10 July 2018

ASICS FACILITY, SYDNEY BUSINESS PARK (SSD 9153) – RESPONSE TO SUBMISSIONS

LONGITUDINAL SECTION ALONG BOUNDAR

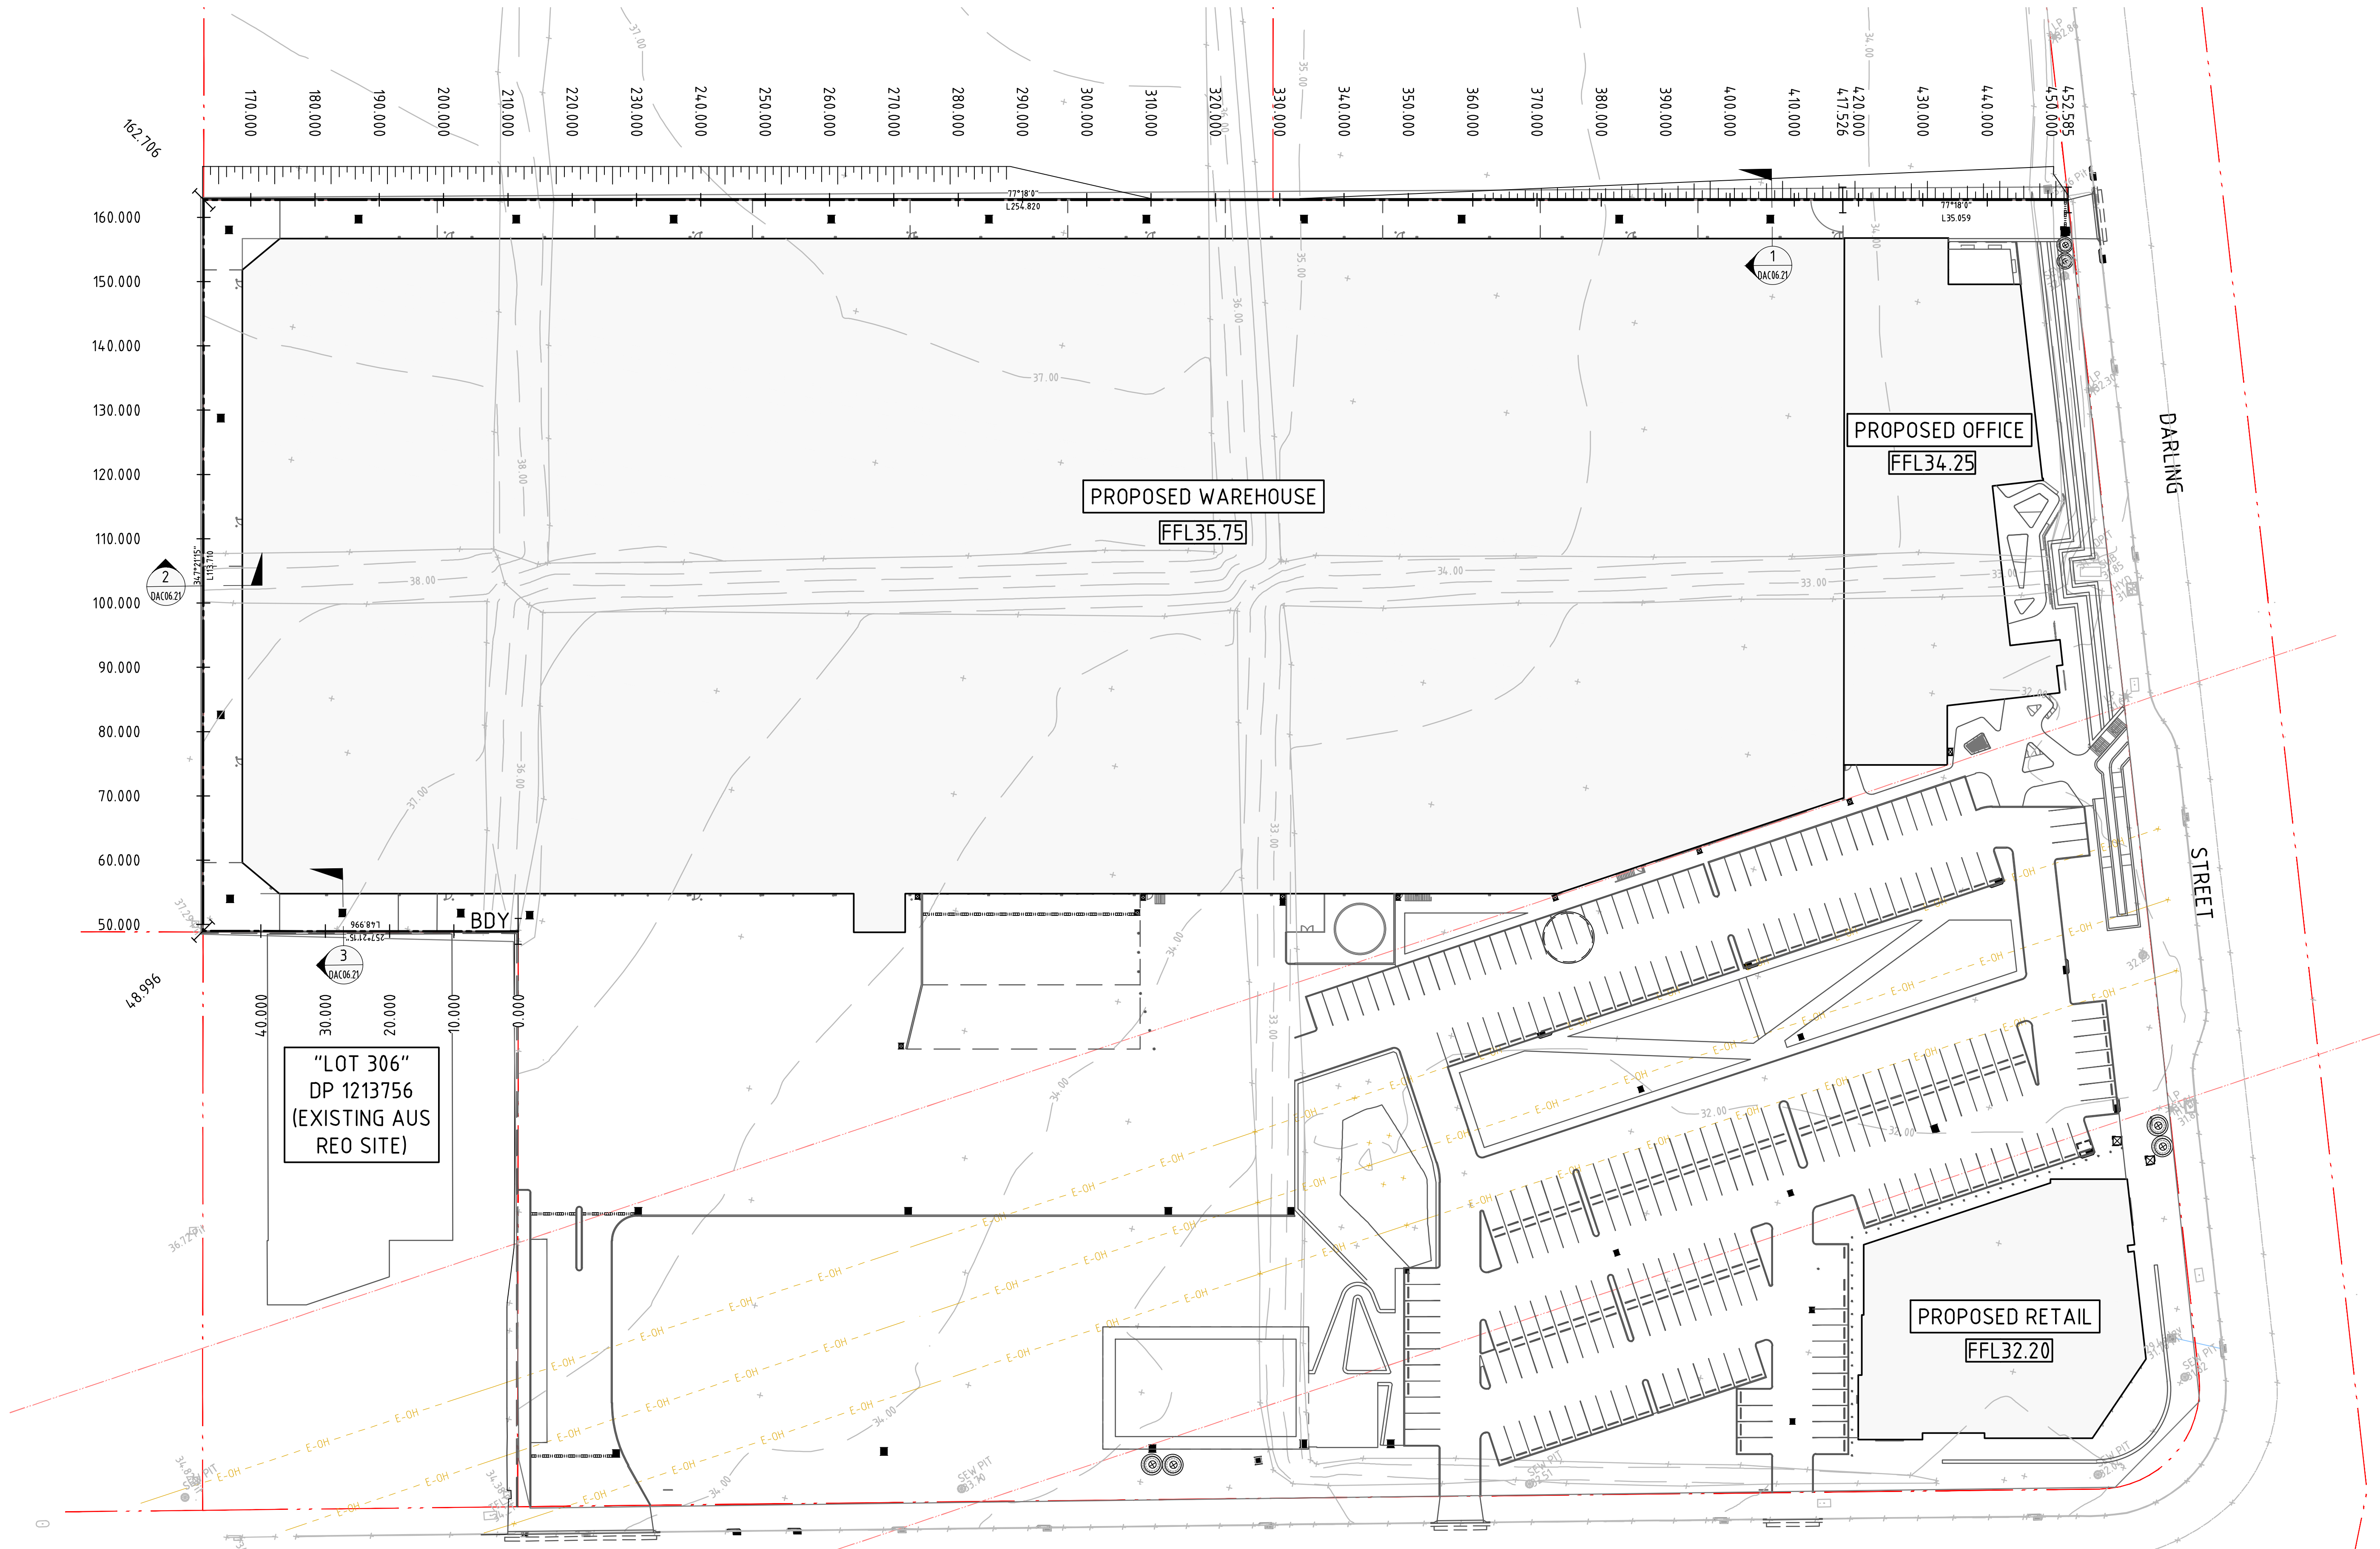
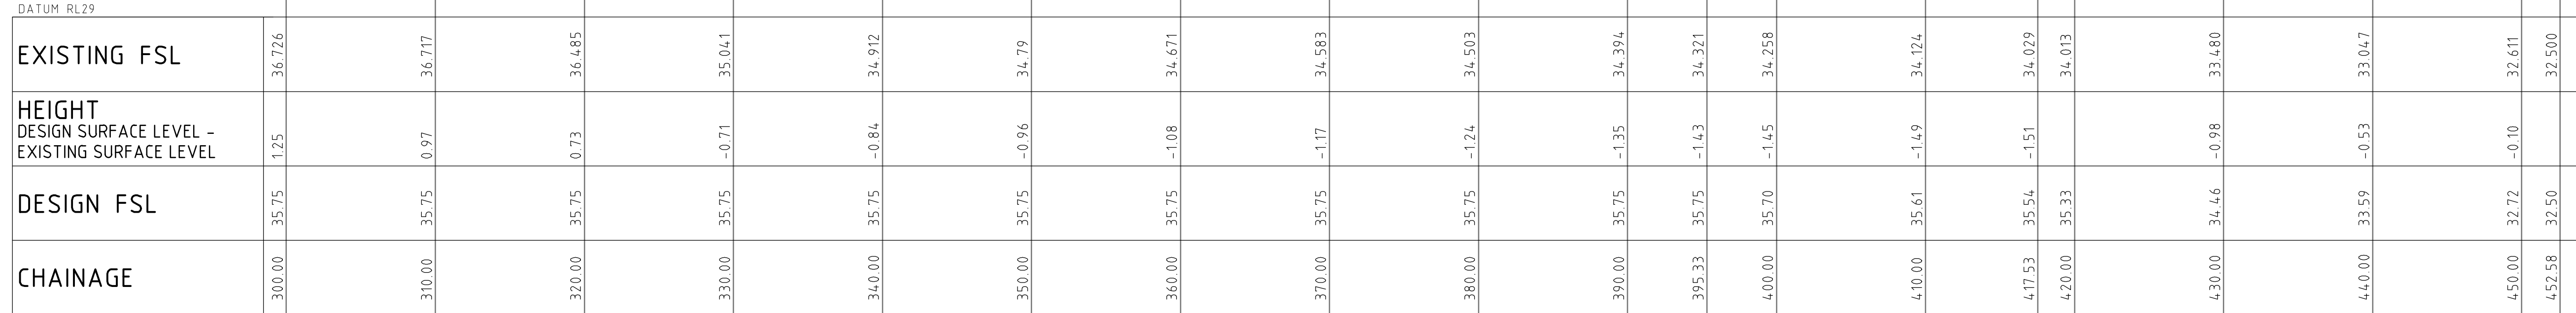
| Aspect | Issue/Recommendation | Response |
|---------------------------|--|--|
| <i>Boundary Treatment</i> | The Applicant is required to provide cross sections in this (north-western) location which demonstrate the anticipated levels of the adjoining lots, including consideration of the likely finished levels to achieve suitable benching for development, fencing, and how level differences will be managed. | The civil design plans have been amended to provide the requested cross sections (see Appendix C). |

LANDSCAPE SITE PLAN
SCALE - 1:500

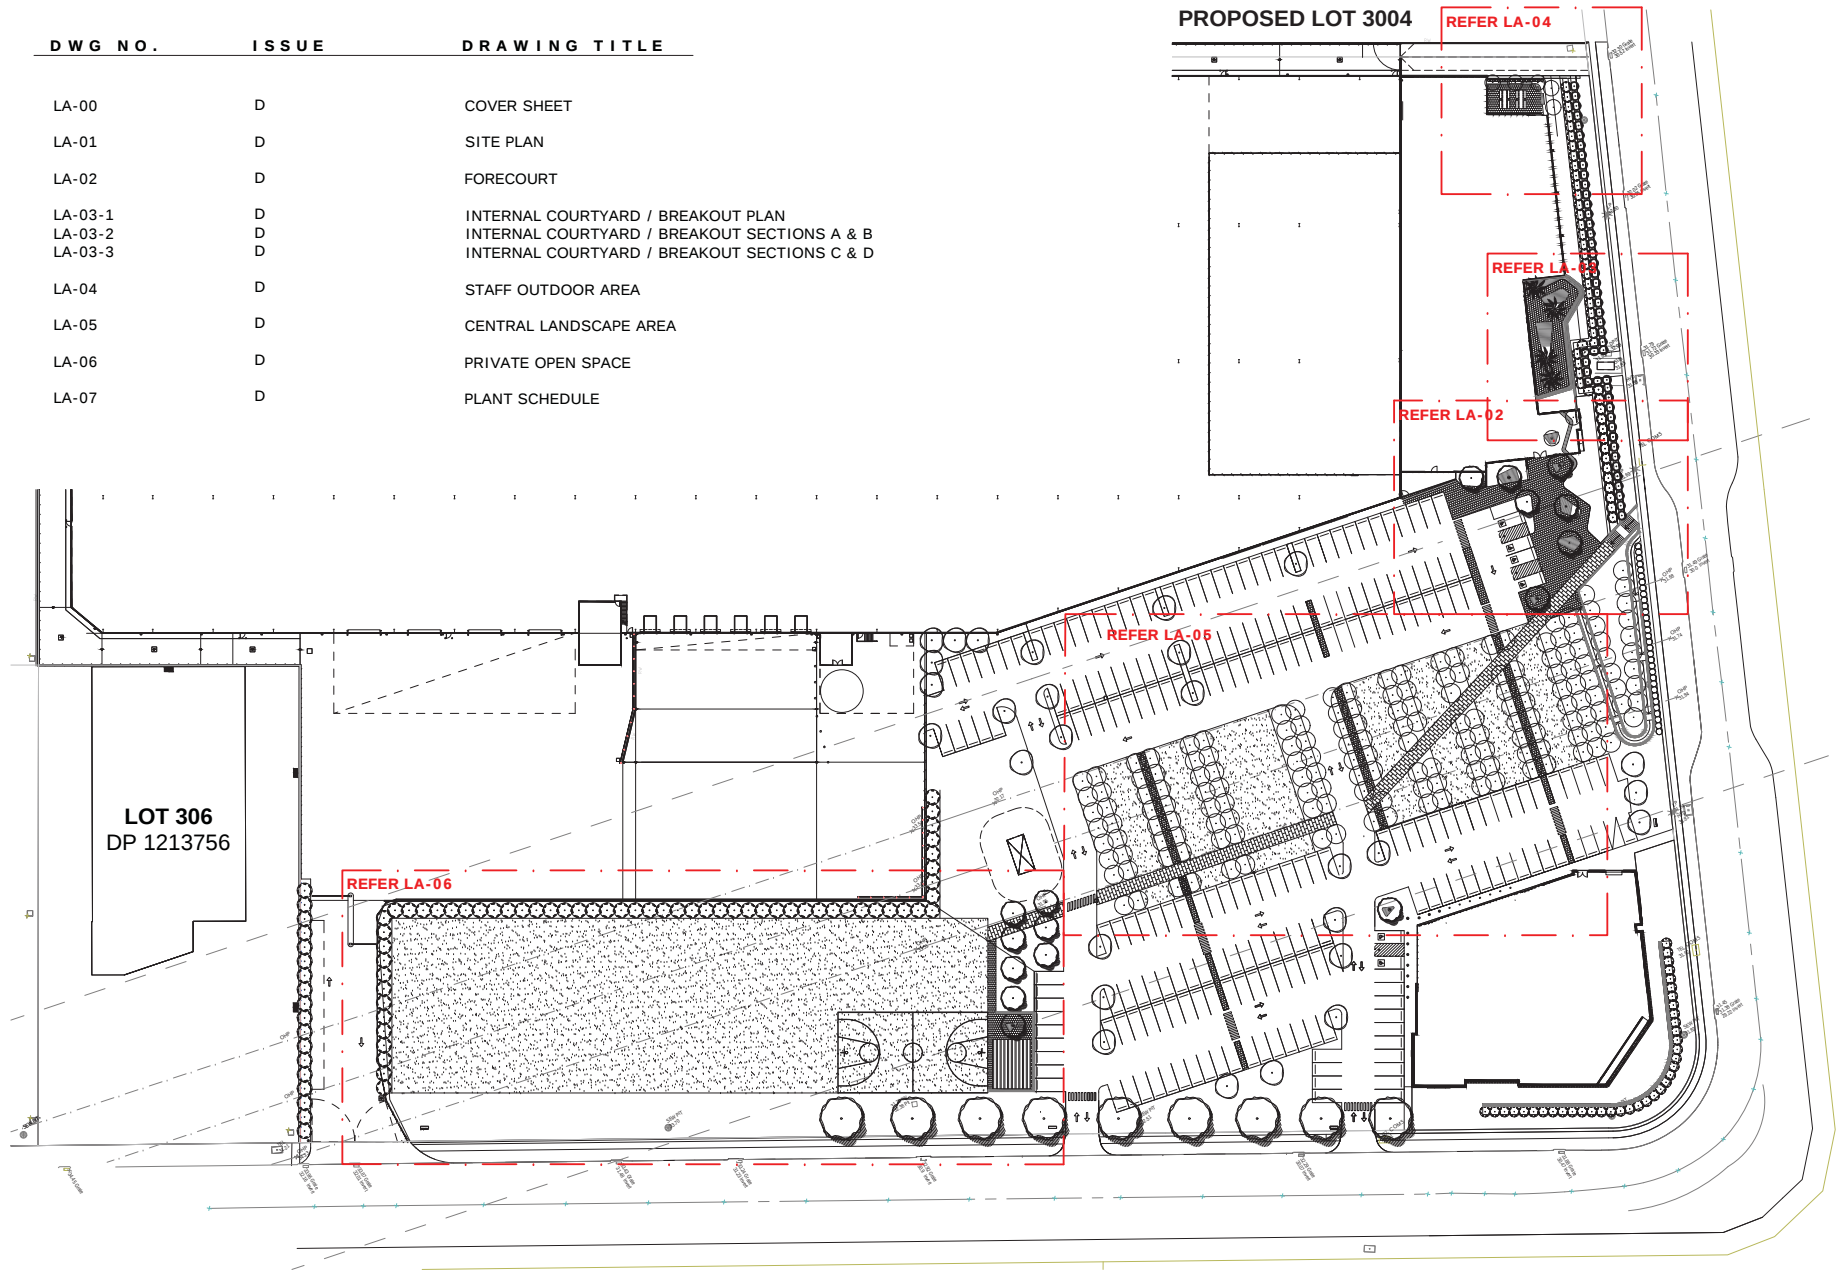
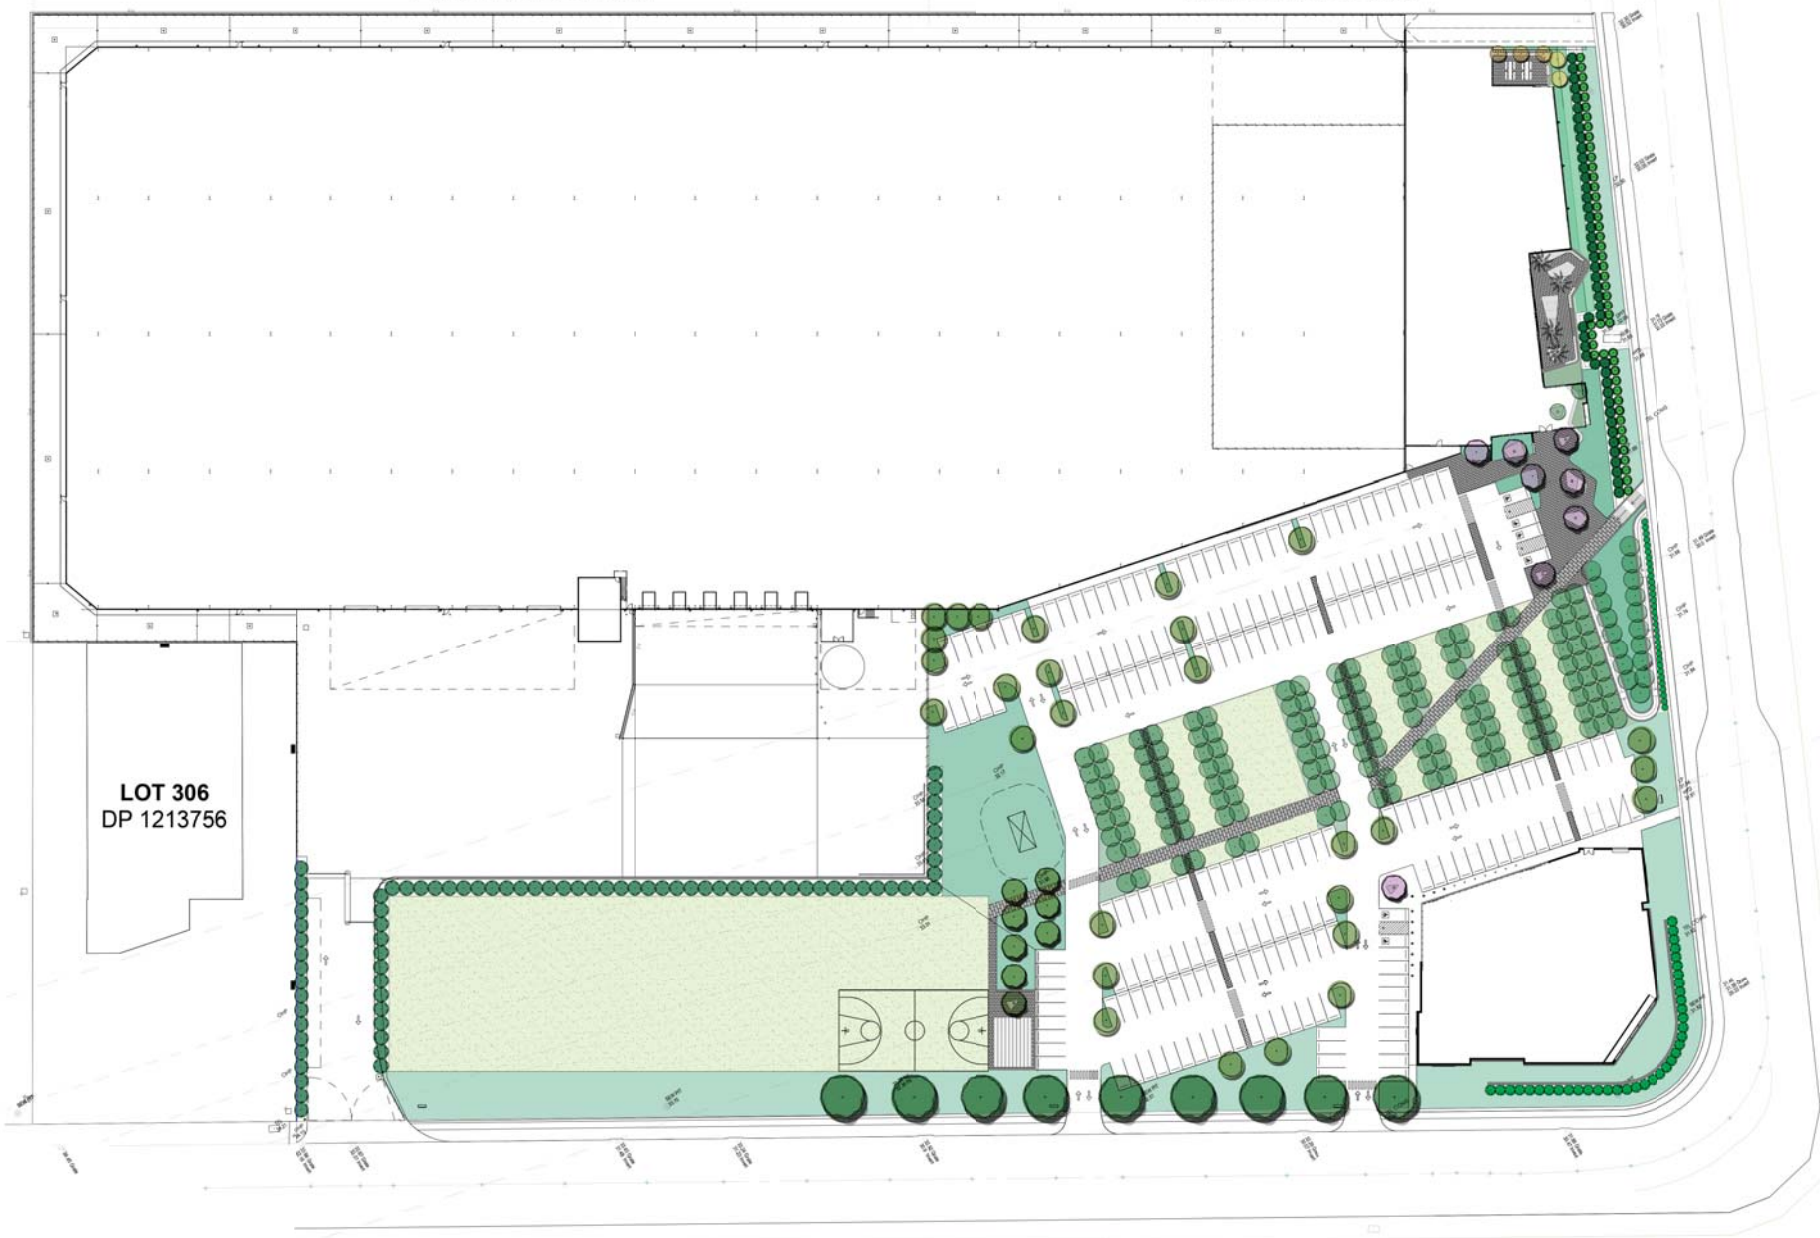
| Aspect | Issue/Recommendation | Response |
|-------------------------------|---|--|
| <i>Design and Visual</i> | Amended plans are requested to be submitted which include the following improvements: <ul style="list-style-type: none"> Additional landscaped zones to the perimeter of the site to provide further soft screening of the development and to further reduce urban heat island effects | <p>The architectural and landscape design plans have been amended to include additional landscaping (see Appendices A and B respectively). Whilst it is considered that the proposed design already contained substantial landscaping (representing some 14% of the site area), additional landscaping has been provided in the following areas:</p> <ul style="list-style-type: none"> along the western side of the truck entry; surrounding the frontage of the retail building; under the transmission lines near the tower base; and along the Darling Street frontage near the office entry. <p>The revised plans provide approximately 9,650m² of landscaping, representing some 17% of the site area.</p> |
| | <ul style="list-style-type: none"> Minimum 2 metre wide landscaped zone to both sides of the truck entry driveway | The architectural and landscape design plans have been amended to include minimum 2 metre wide landscaping zones on both sides of the truck entry in the south-western corner of the site (see Appendices A and B). |
